Certificate of Occupancy

LOCATION 27 Monument Sq CBL 027 F002005

RE: 27 (28) Monument SQ
CBL: 027 F002
Permit #07-1017/09-0416

List of code corrections to be addressed for certificate of occupancy:

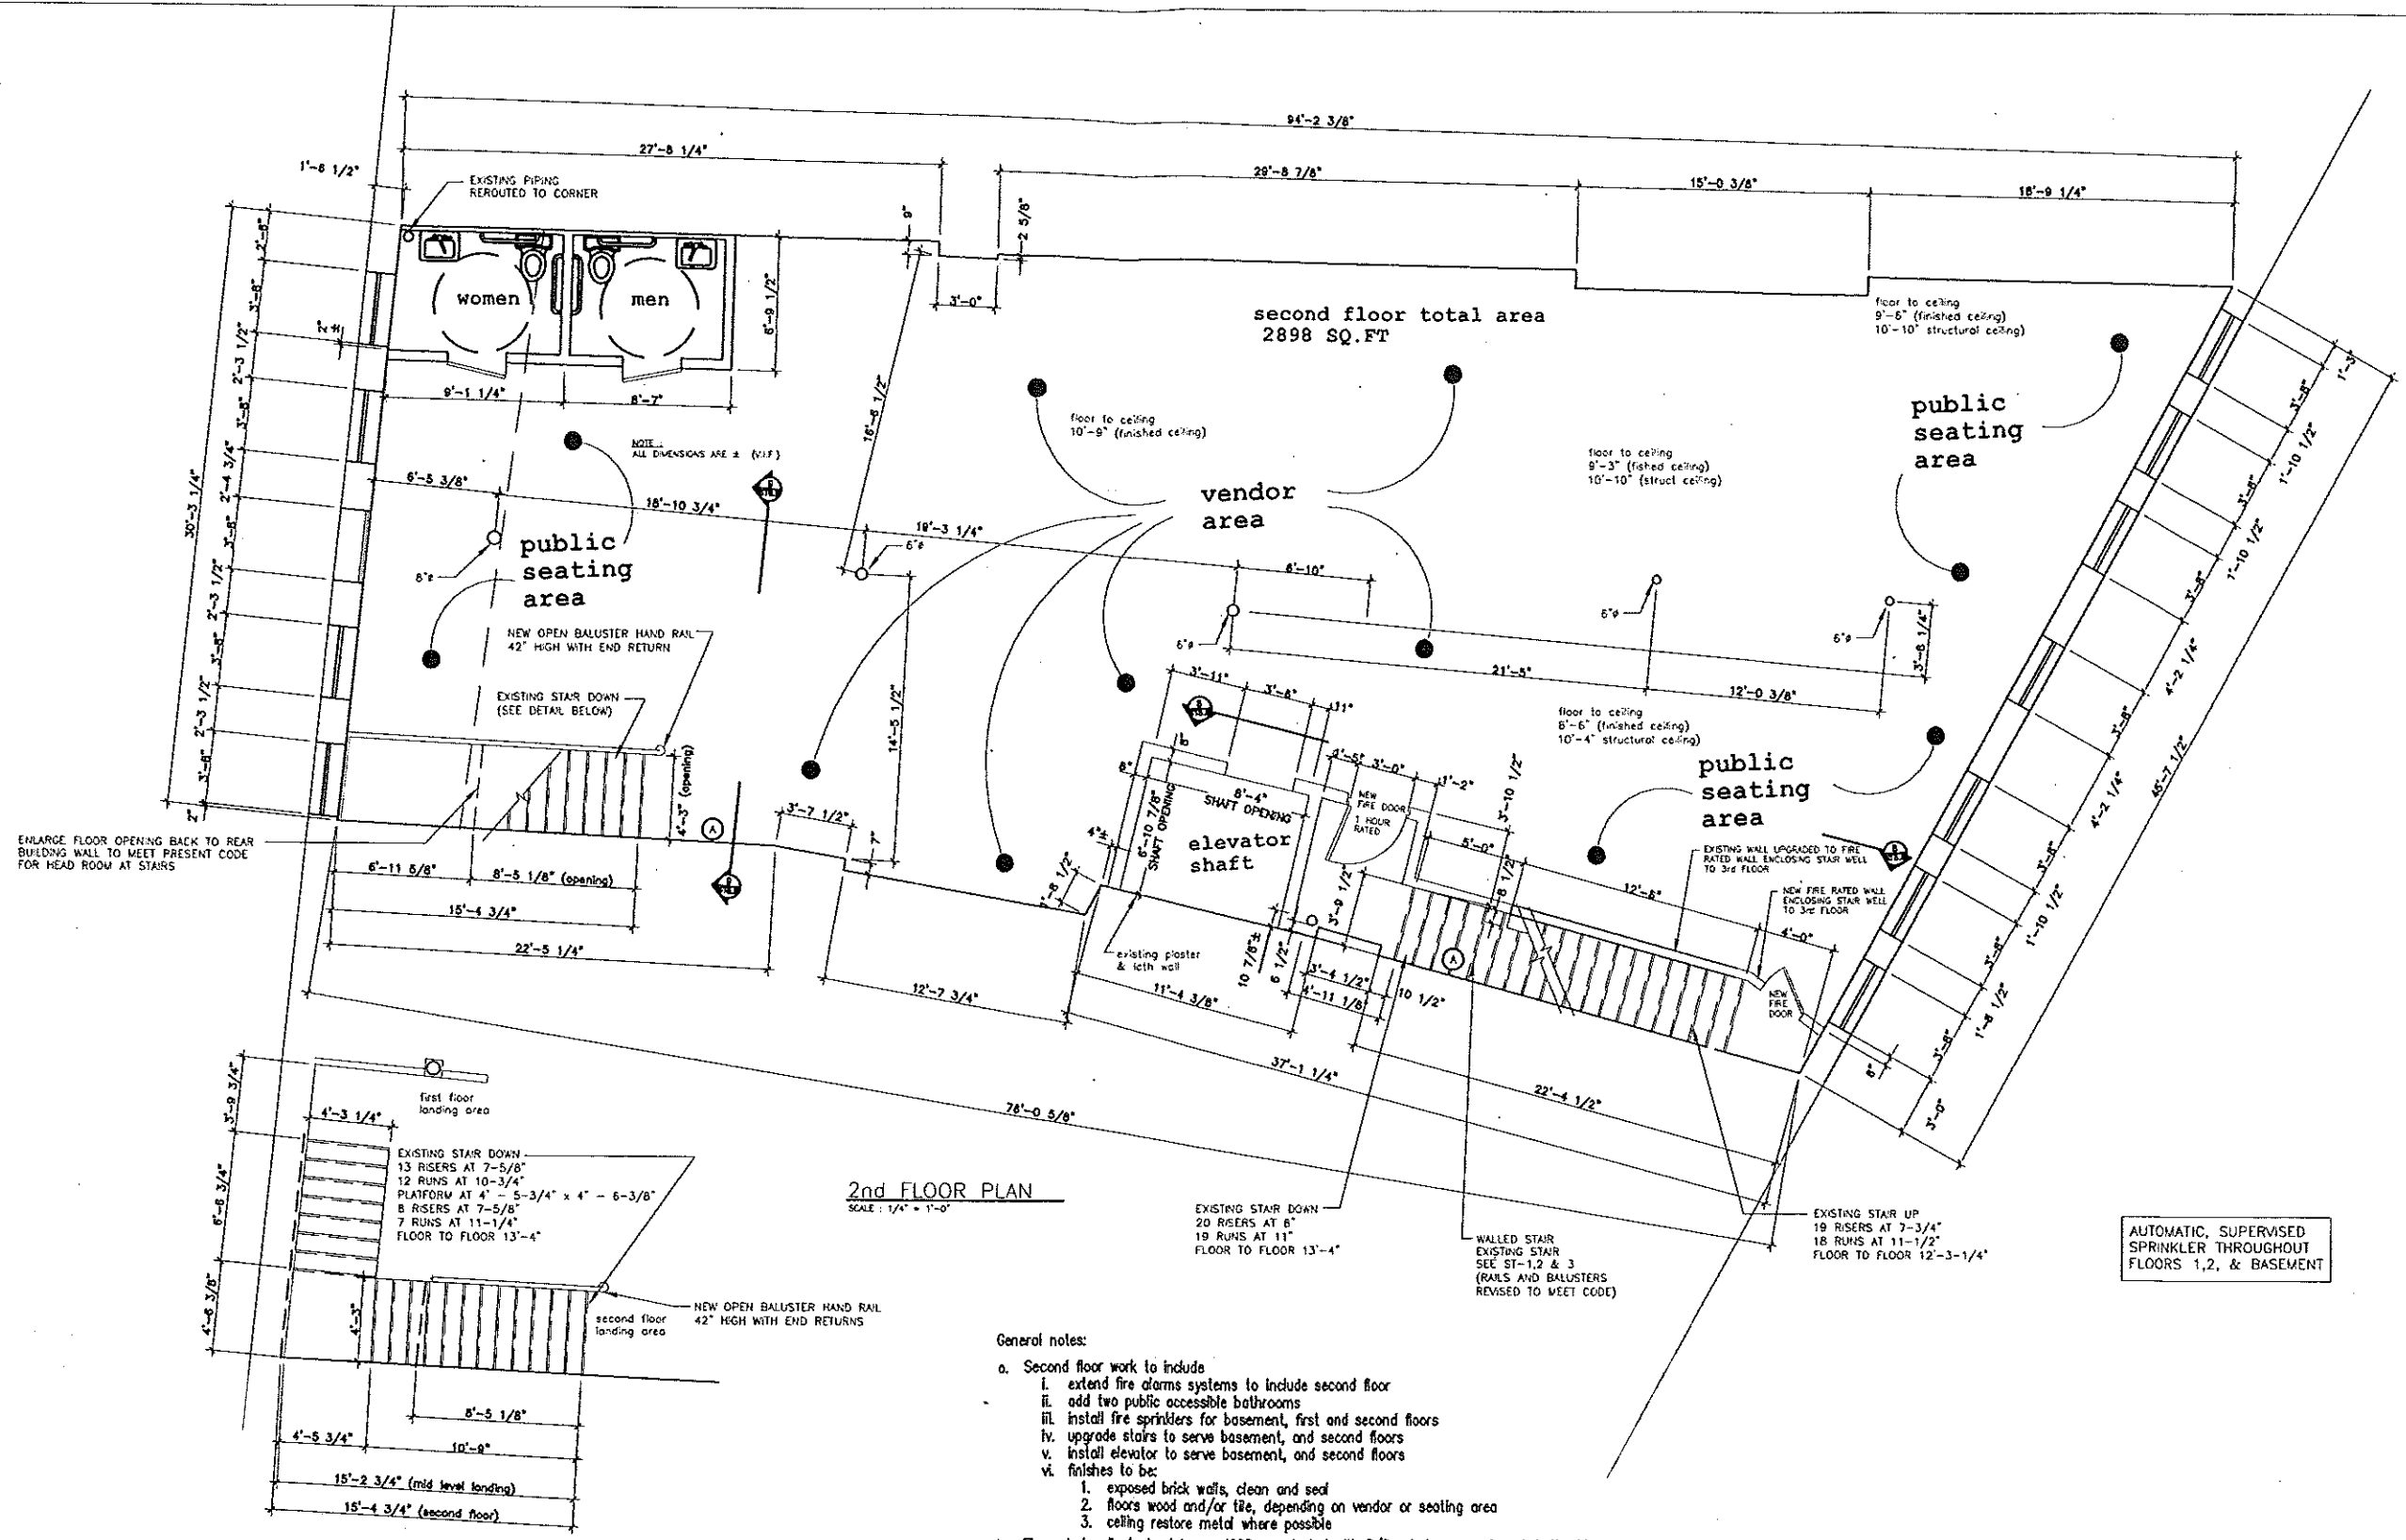
7. Address floor/ceiling rating at 2nd floor at electric room/bathroom and protect penetrations
8. Correct illegal wiring of existing kitchen hood exhaust at 2nd floor exterior roof, also permit required to address the relocation of the exhaust termination adjacent to residential occupancy

9. Relocate existing plumbing vent stacks that terminate at the rear 2nd floor roof adjacent to the new residential occupancy
10. Address walk in cooler (new) AC unit, venting, condensate and health code specs, letter to follow
